# HINCKLEY NATIONAL RAIL FREIGHT INTERCHANGE

*Blaby District Council (IP ref.  
20040018) Deadline 8  
submission: Comments on  
Deadline 7 submissions and  
dDCO (ref. TR05007).*

**Deadline 8 – March 08, 2024**

Fig 17. Illustrative Public rights of Way

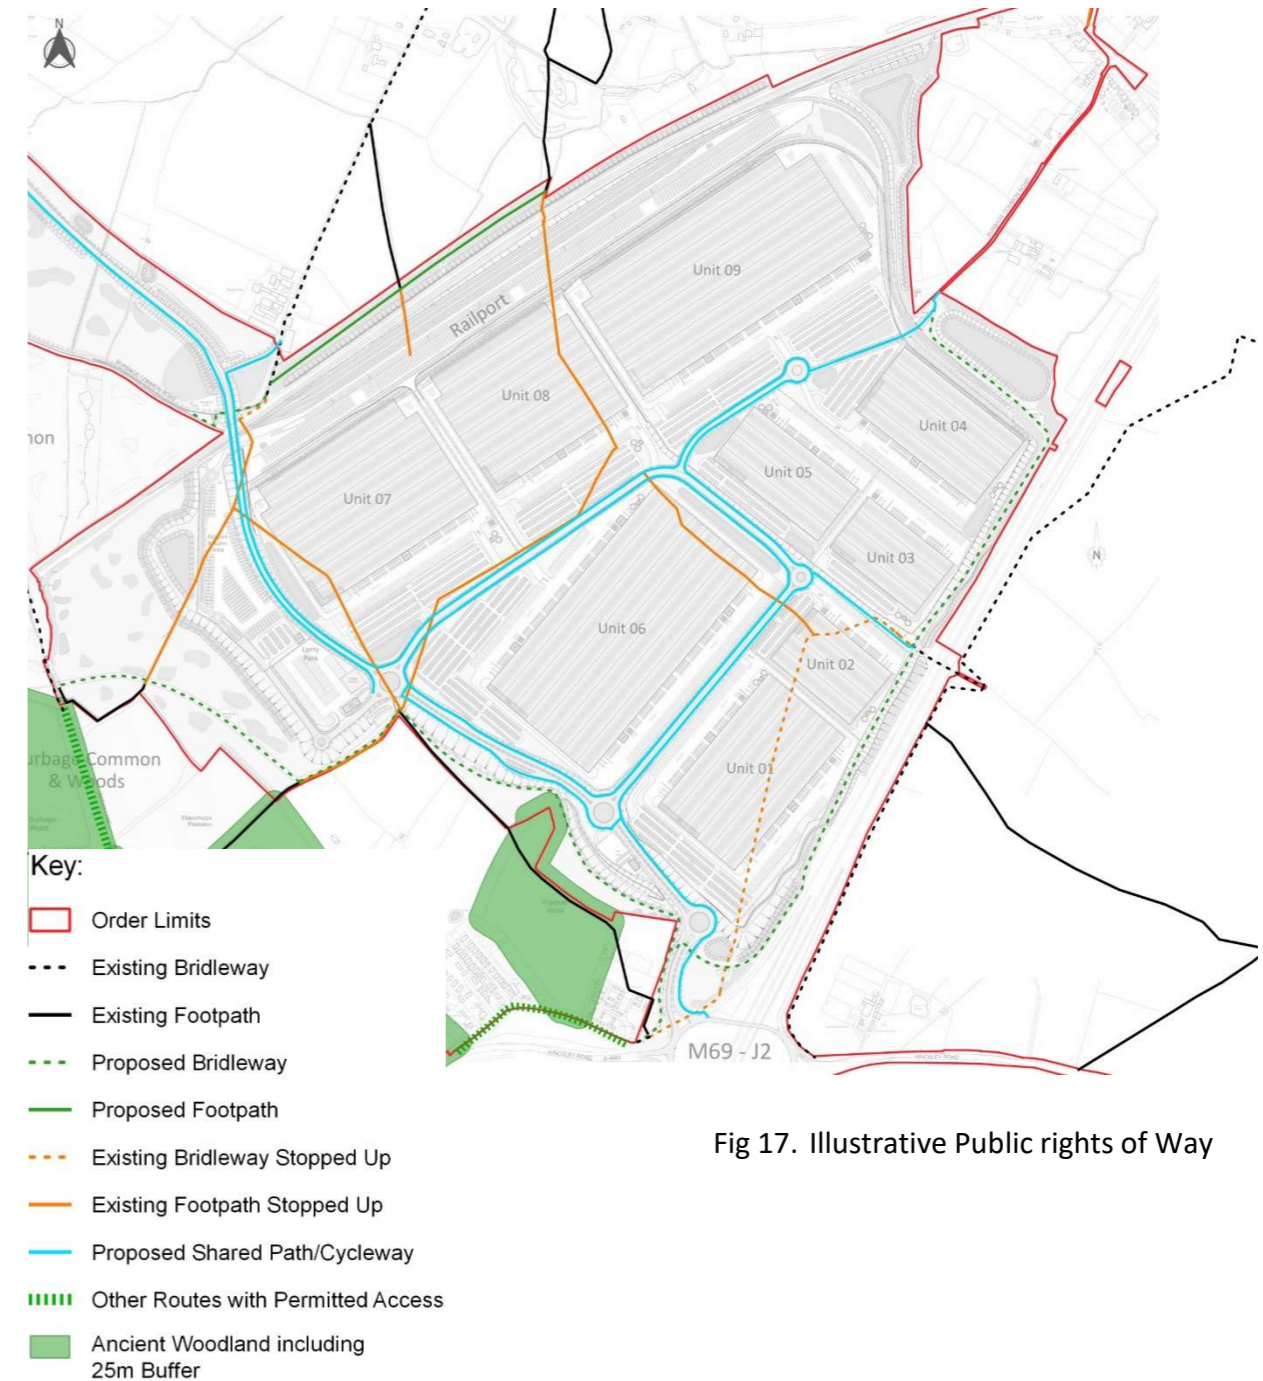
13.1C	Design Code	<p>BDC acknowledge the submission of a revised Design Code and have detailed further comments on this below;</p> <p><u>Pages 14, 15 and 35</u> It is noted that there is reference made to a revised colour masterplan/diagram. BDC is of the assumption that this is to accommodate the new cycle route north of the railway, although, this is unclear.</p> <p><u>Page19 (Amenity areas)</u> The addition of the Applicant’s statement; “<i>subject to the agreement of the local planning authority</i>” for planting along estate roads and the detailing of swales is welcomed.</p> <p><u>Pages 21 and P22 - Sections 6.1 &amp; 6.3</u> The Applicant has added “<i>The details associated with this design principle will be subject to Local Highway Authority technical approval where relevant</i>”. BDC welcome this approach, however, it is unclear which areas specifically this statement refers to and therefore, it is difficult to assess its true value.</p> <p><u>Page 34 - Section 8.5.1 (Public rights of way – specific codes)</u> The Applicant has added a separate point which states; “<i>Create a new combined footpath and cycle route north of the new bridge to connect the development with the existing public bridleway network</i>”. BDC welcome this addition, however, BDC have commented on the loss of both visual and physical amenity that users of the replacement Public Rights of Way (“PROW”) will experience. This route down the side of a railway embankment appears unlikely to meet the attractiveness of the current PROW’s and therefore, this does not alleviate the previously raised concerns on this matter.</p>
